# Rezoning Transportation Analysis

Petition Number: Zoning Petition #2021-019

Date	Description
02-25-2021	First Review (KP)
08-23-2021	Second Review (KP)
09-17-2021	Third Review (KP)
11-04-2021	Fourth Review (KP)
11-22-2021	Fifth Review (KP)

REZONING SITE PLAN SCALE 1" = 60'

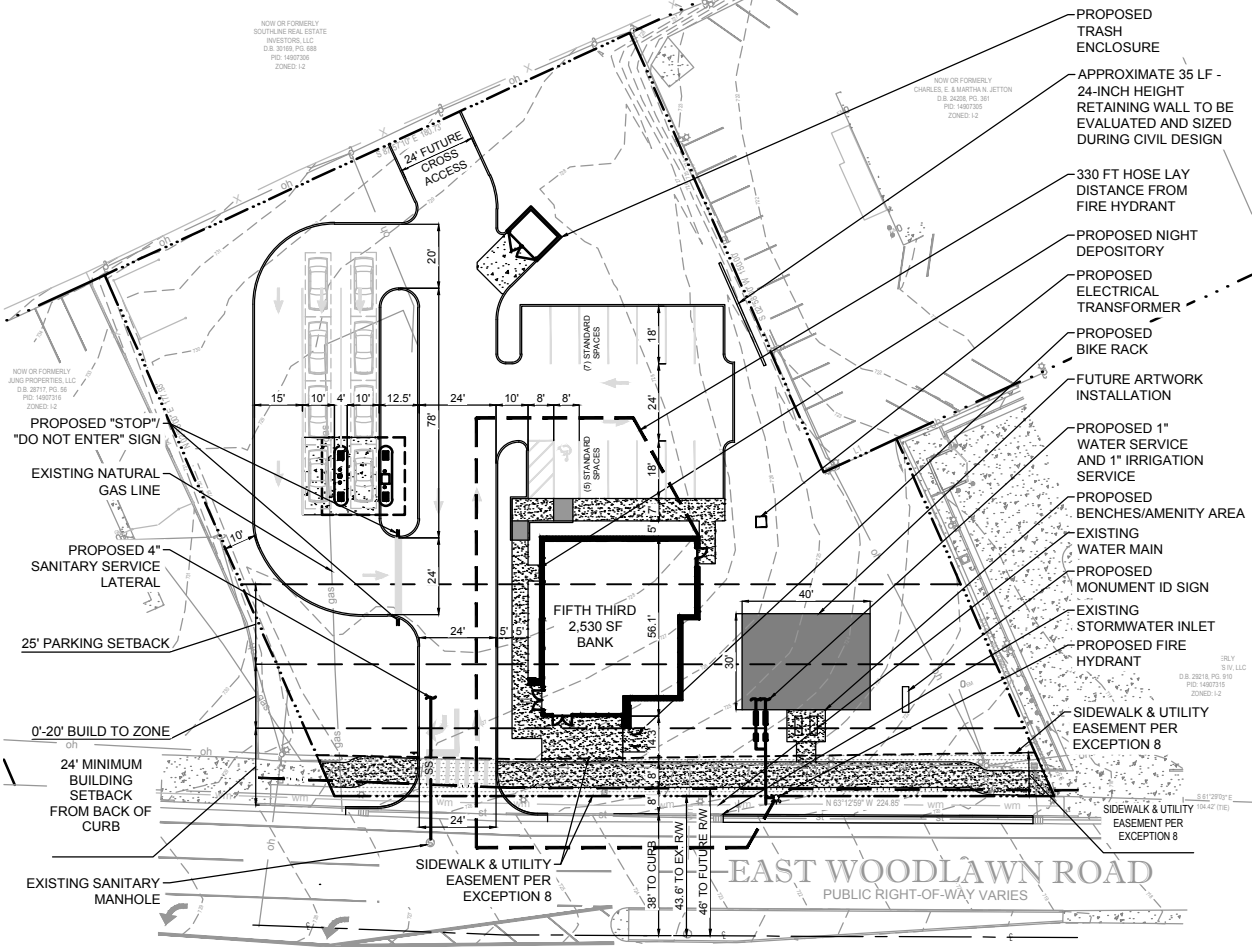
### 2. ~~Including a conditional note that the proposed site access, off Woodlawn Road, will be subject to NCDOT recommendations and approval, to be coordinated during the permitting process.~~

### 3. ~~A site plan note(s) specifying dedication and fee simple conveyance of all rights-of-way to the City and/or NCDOT before the site's first building certificate of occupancy is issued is needed. CDOT requests rights-of-way set at 2' behind back of sidewalk where feasible.~~

### 4. ~~A site plan note specifying that all transportation improvements will be approved and constructed before the site's first building certificate of occupancy is issued is needed. The petitioner may phase transportation improvements if said improvements and phasing are explicitly described in site plan notes.~~

~~5. Revise the conditional notes by including the following note:~~

~~All public roadway improvements will be subject to the standards and criteria of CDOT and NCDOT, as applicable, to the roadway improvements within their respective road system authority. It is understood that such improvements may be undertaken by the Petitioner on it's own or in conjunction with other development or roadway projects taking place within the broad south Mecklenburg area, by way of private/public partnership efforts or other public sector project support.~~
